Response to Exhibition of Proposed Residential Buildings at 10, 14 and 14a Stanhope Road, Killara (SSD-81890707)

I object to the proposed development.

Comments regarding the Stormwater system, Easement and Flooding

BASEMENT 1 PLAN

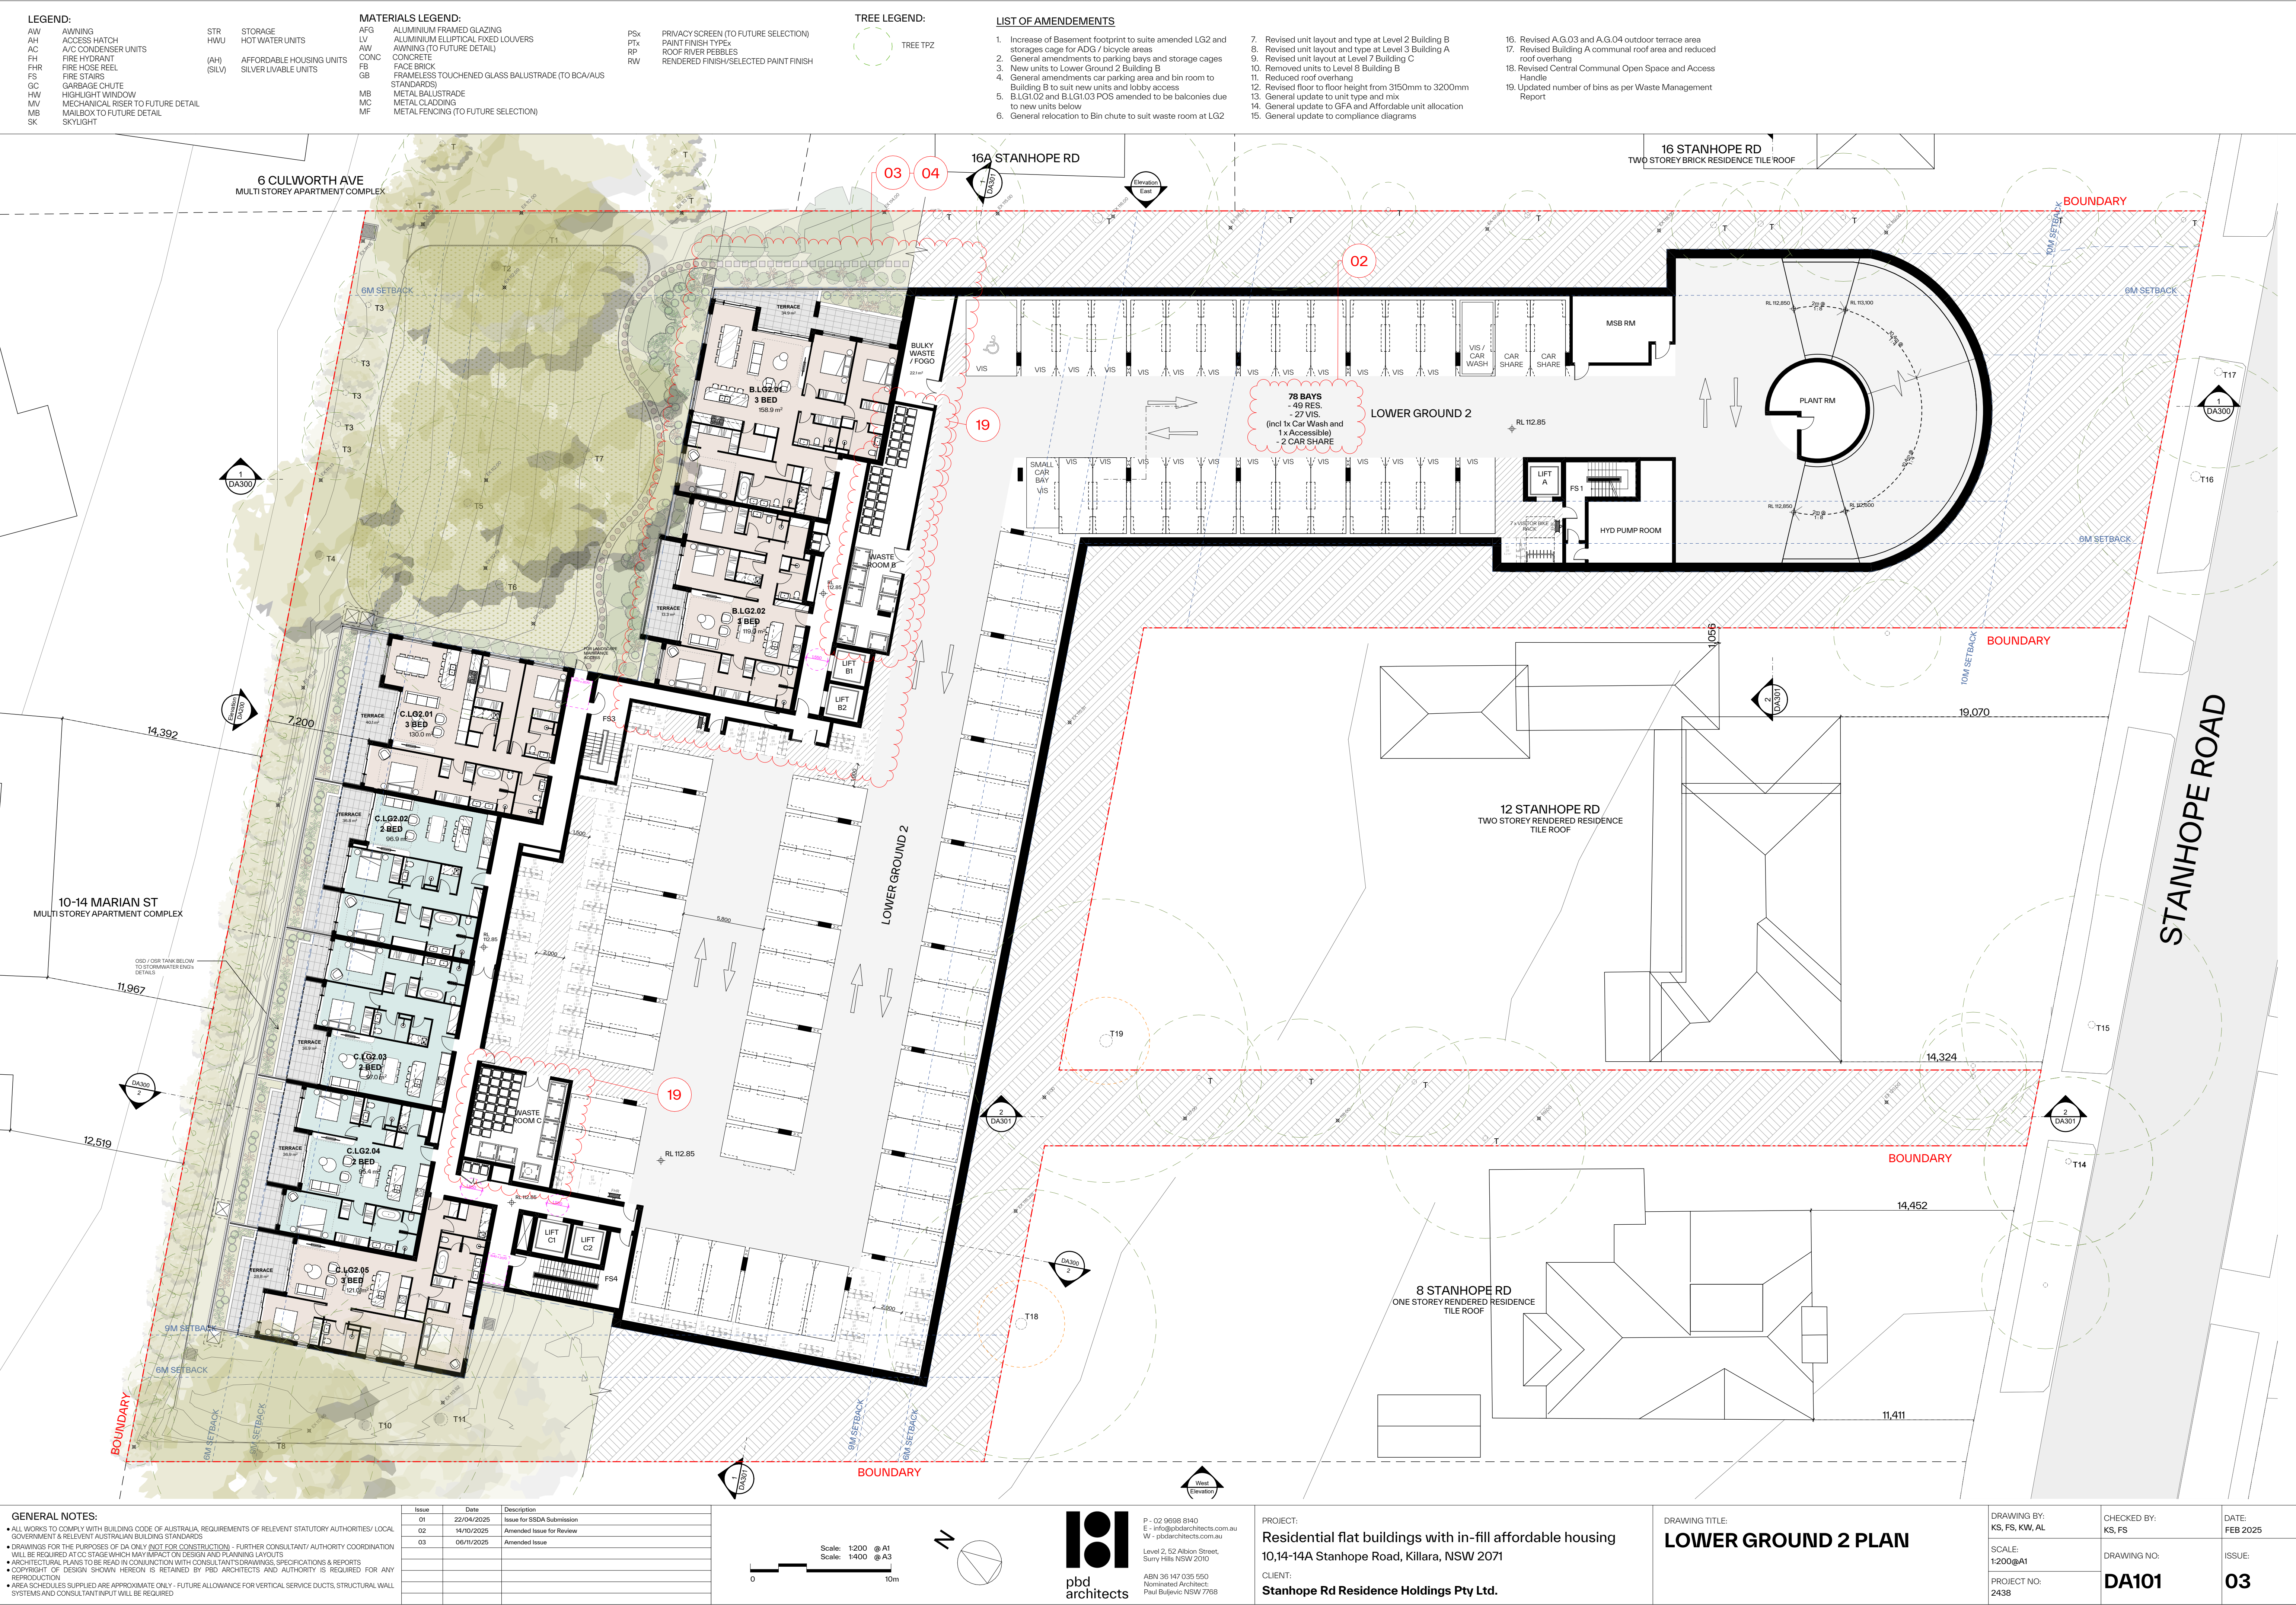
The basement has been increased in size to accommodate the car parking requirements that were lost on lower ground 2 level as a result of the two new units. The basement has been slightly extended to the north and includes car parking spaces and bicycle storage.

Slightly is an understatement. The excavation has advanced significantly towards the boundary with 10 Marian Street, increasing the proximity of construction, excavation, noise and dust etc. to the Marian Street neighbours. It also cramps the Retention/Detention tank constructions against the boundary encroaching on the 6m set-back and is therefore a retrograde step.
